RE: M-51 Industrial– Response to City Comments

Please refer to our responses below which address all review comments received from the City of Marysville on September 1, 2023, regarding the M-51 Industrial submittal package. You will find the markup comments listed in the order that they were written followed by our response in *italics*.

A PORTION OF THE NW 1/4, SW 1/4, SEC 27, TWN 31 N, RGE 5 E, W.M. CITY OF MARYSVILLE, SNOHOMISH COUNTY, WASHINGTON

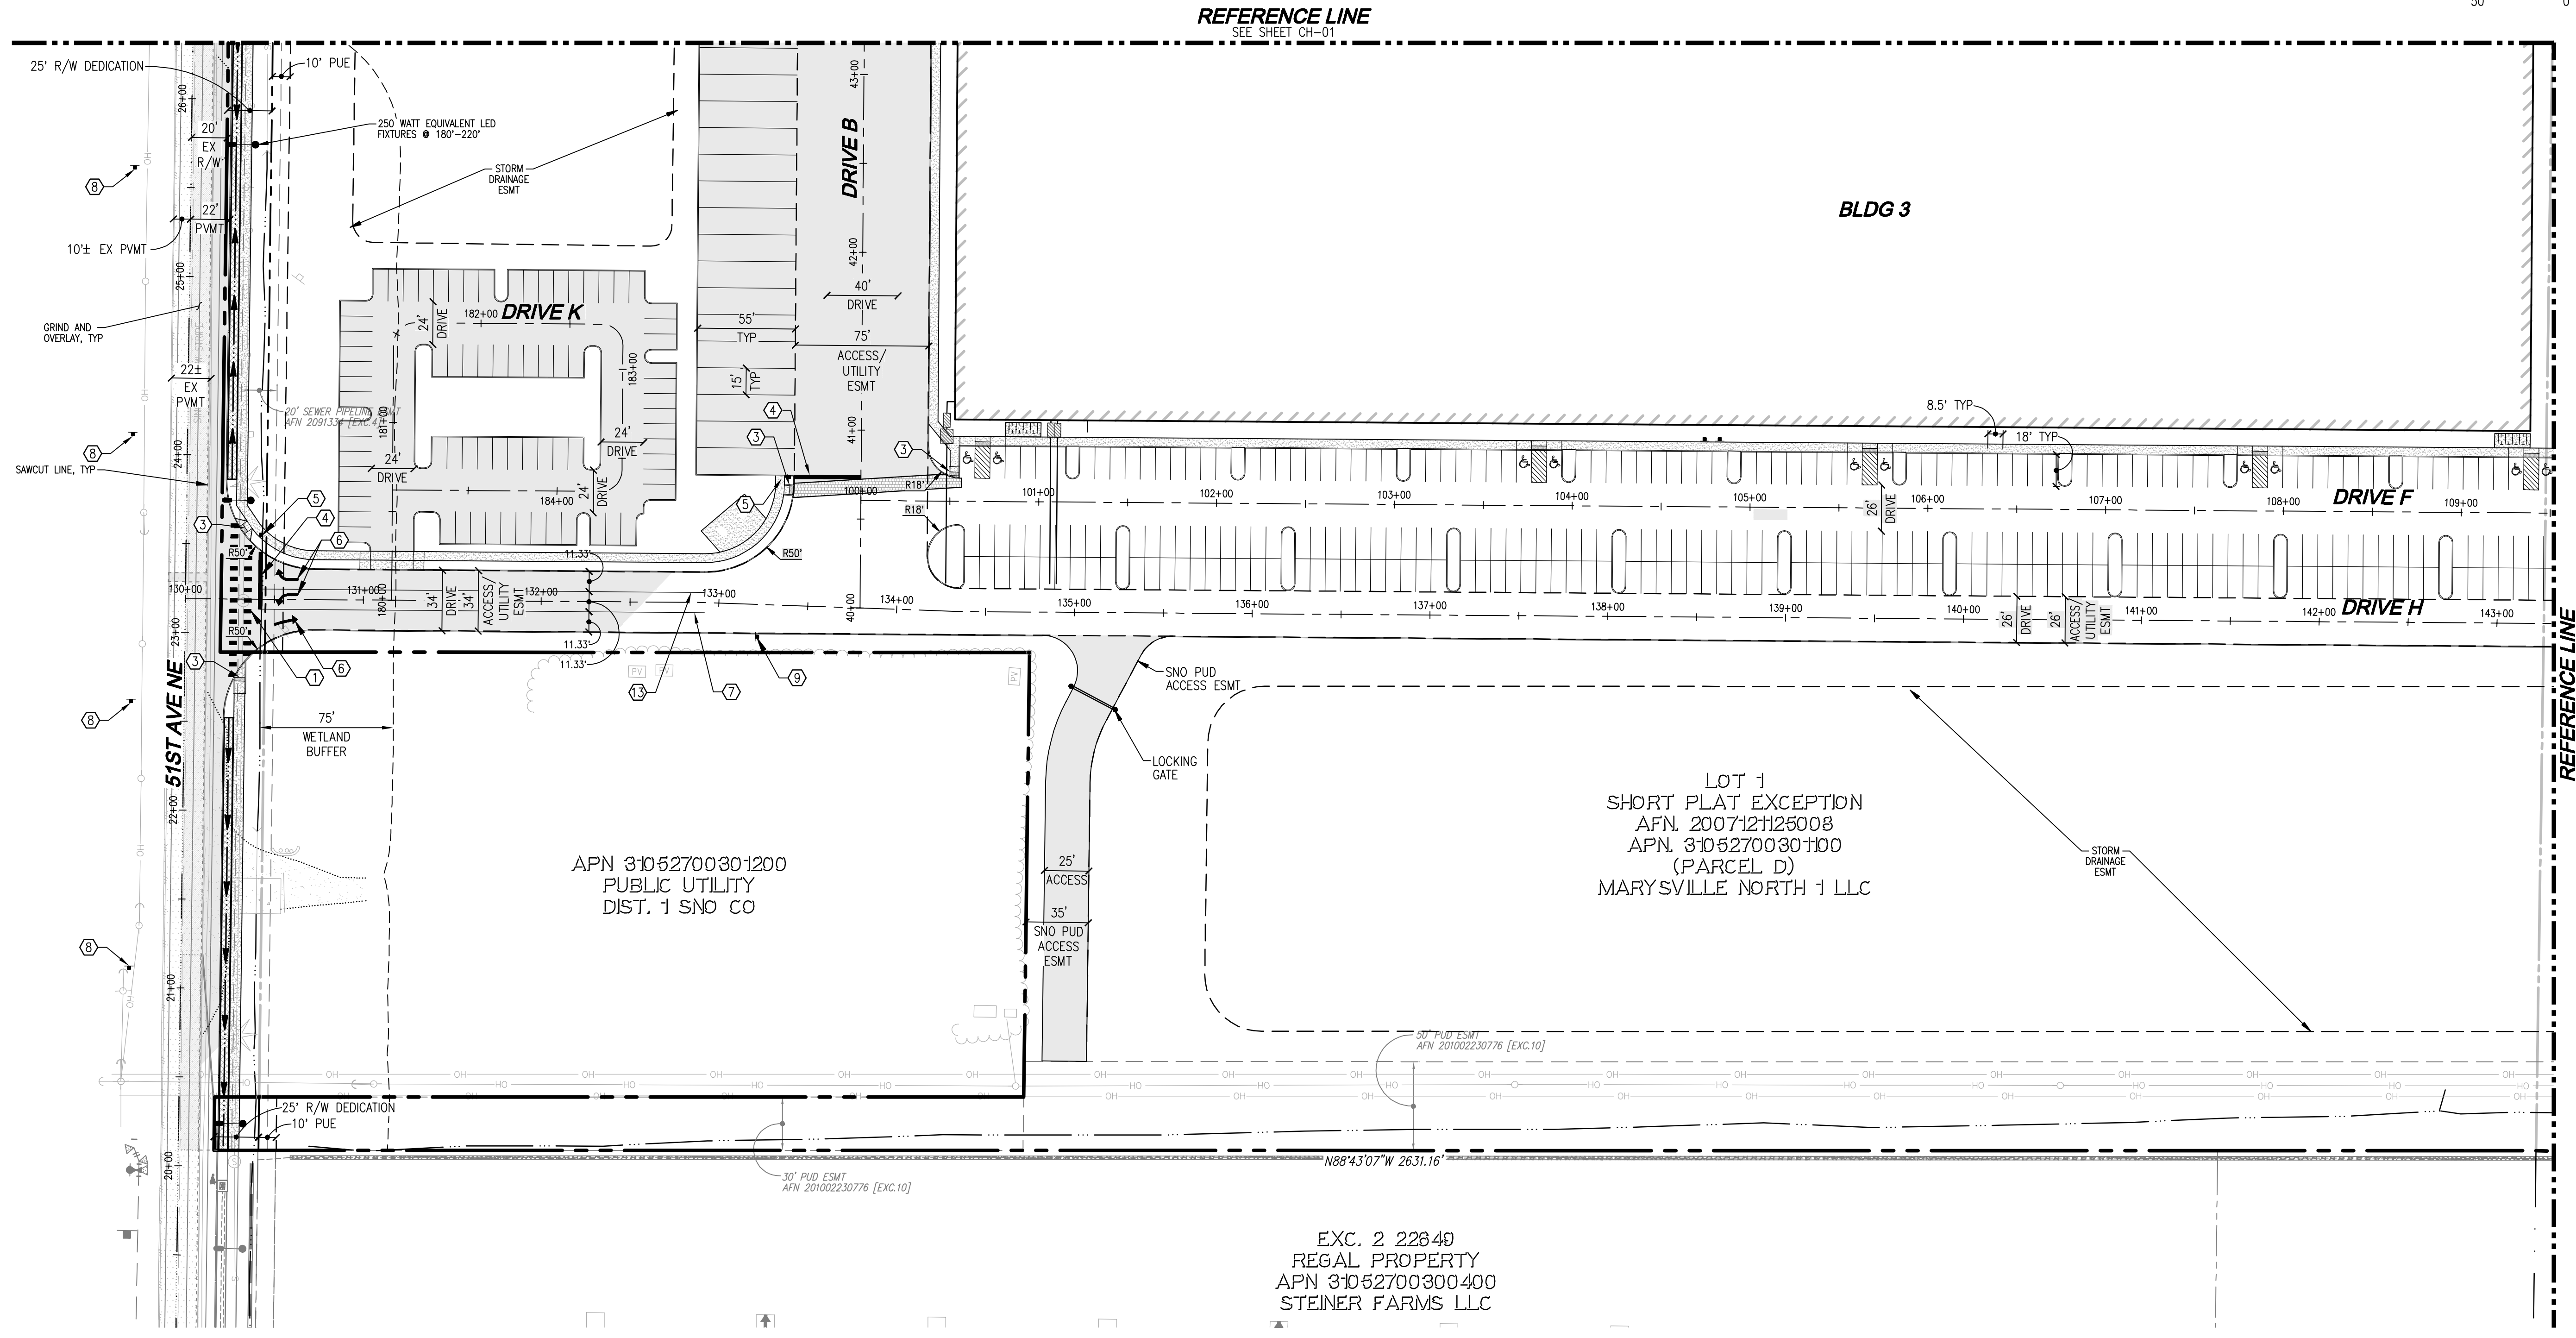
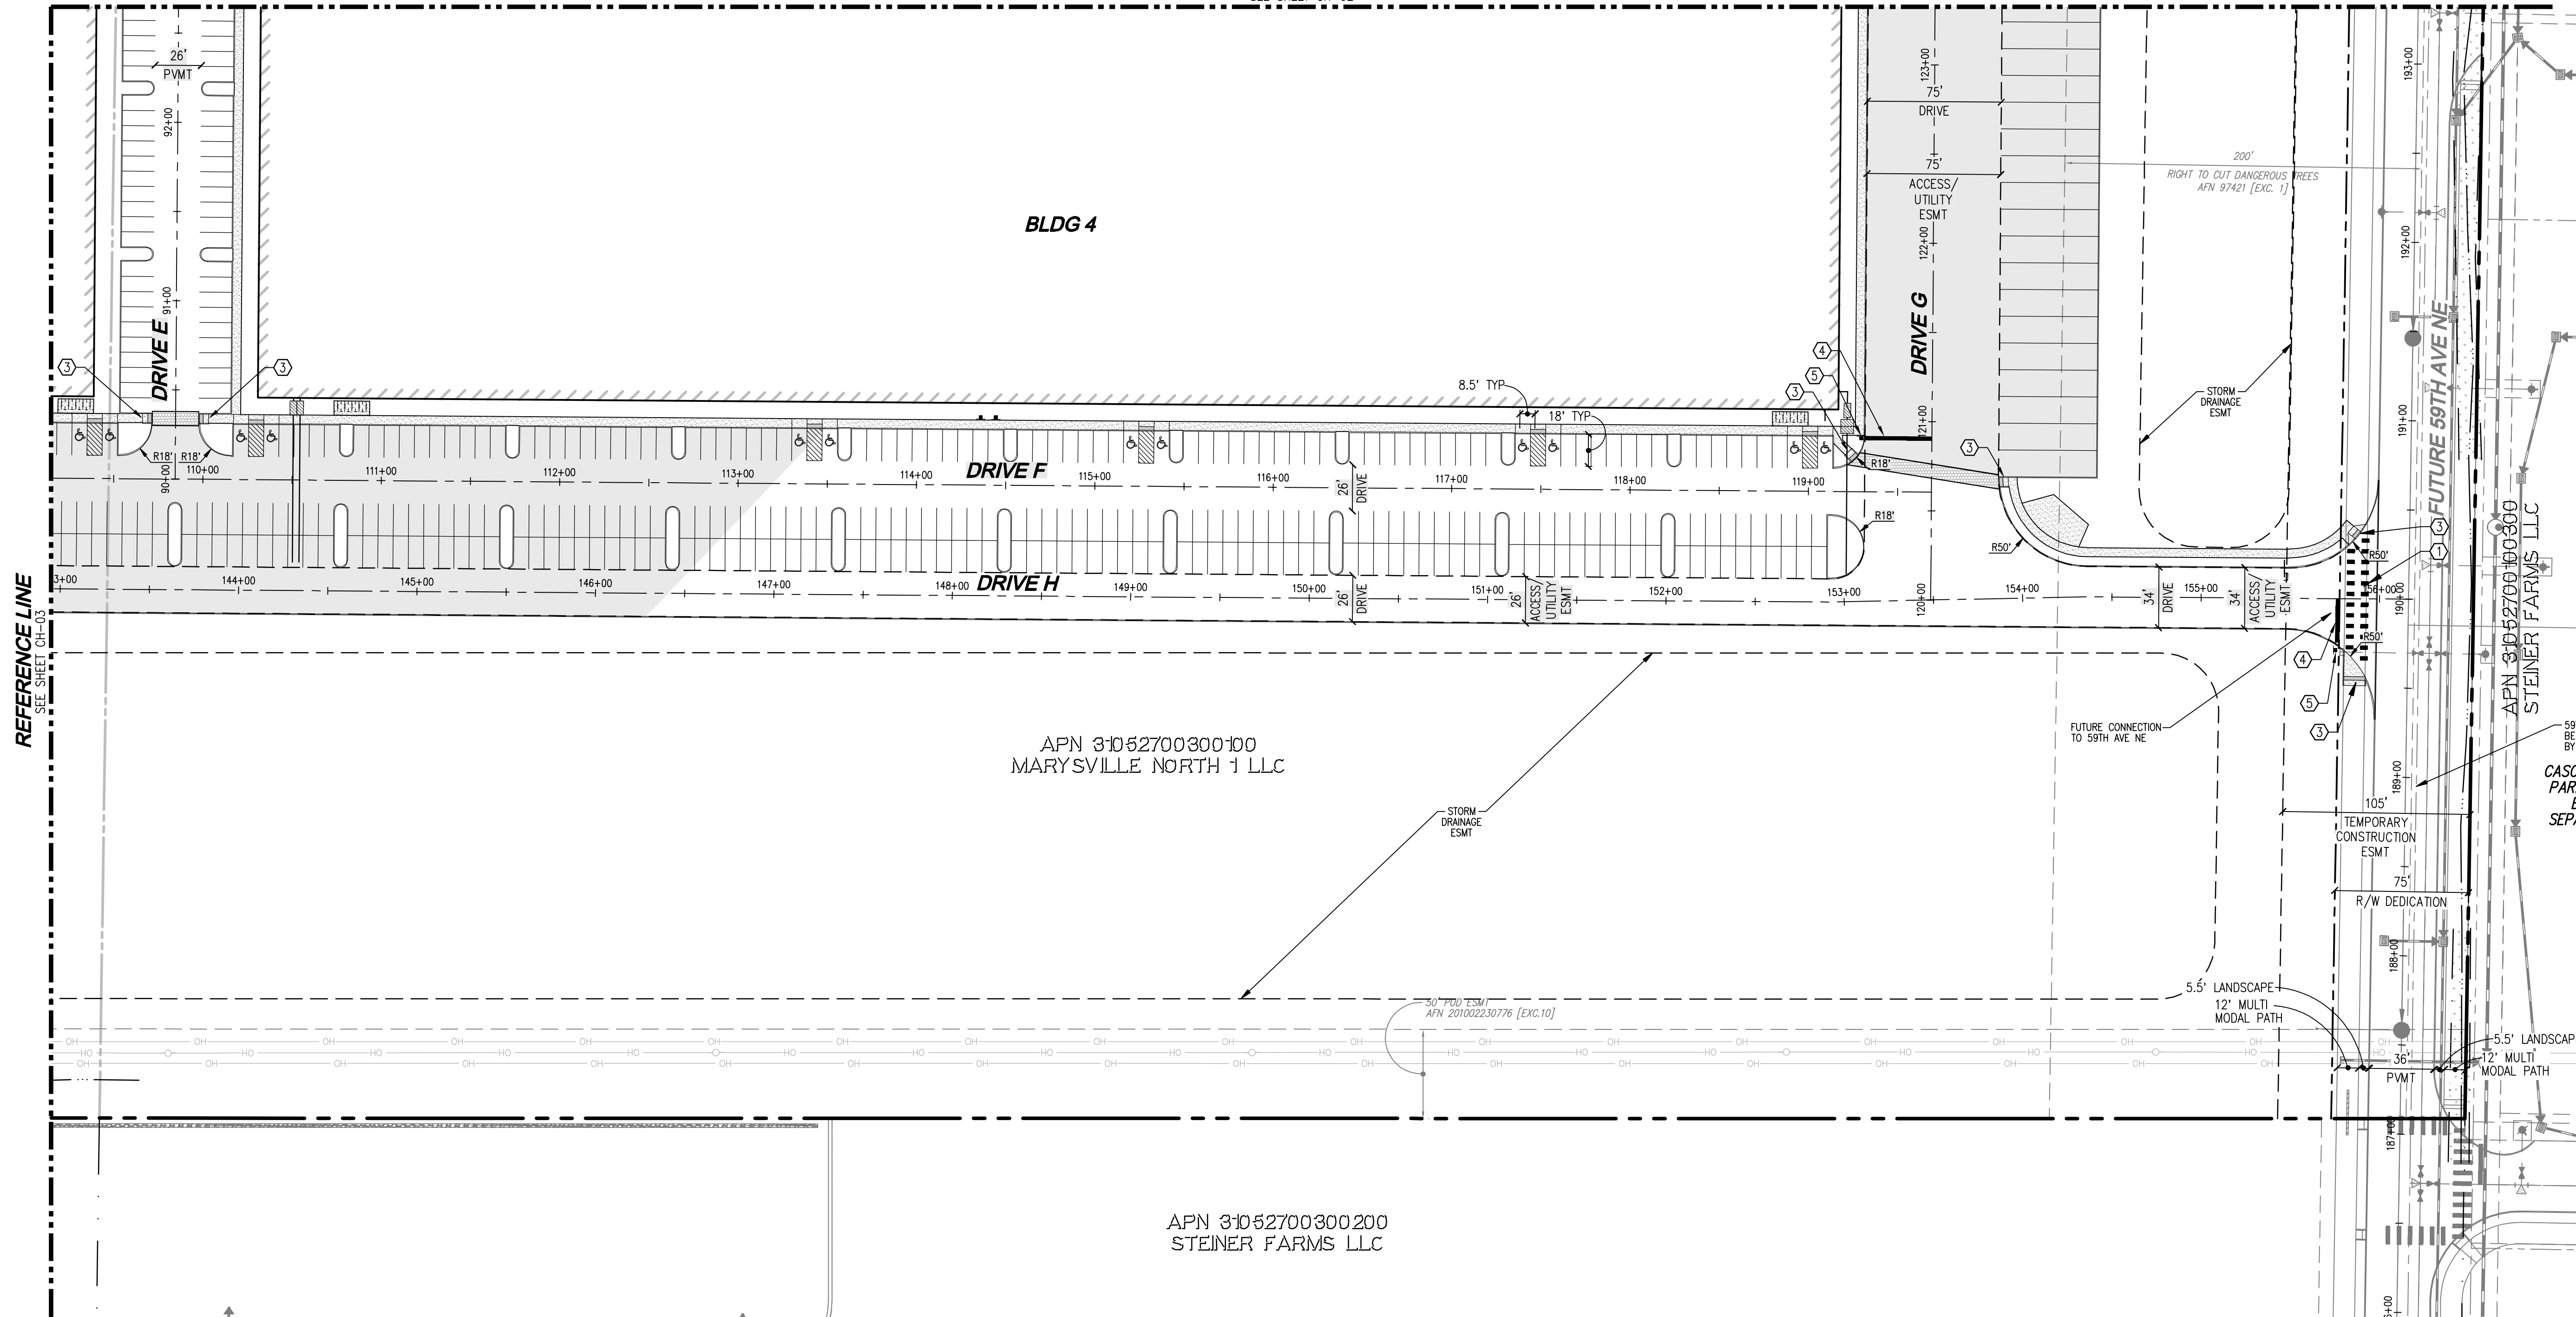
15. Provide auto-turn exhibit demonstrating vehicle and truck traffic can navigate the drive-aisles.

Response: Added Auto-turn diagrams as noted.
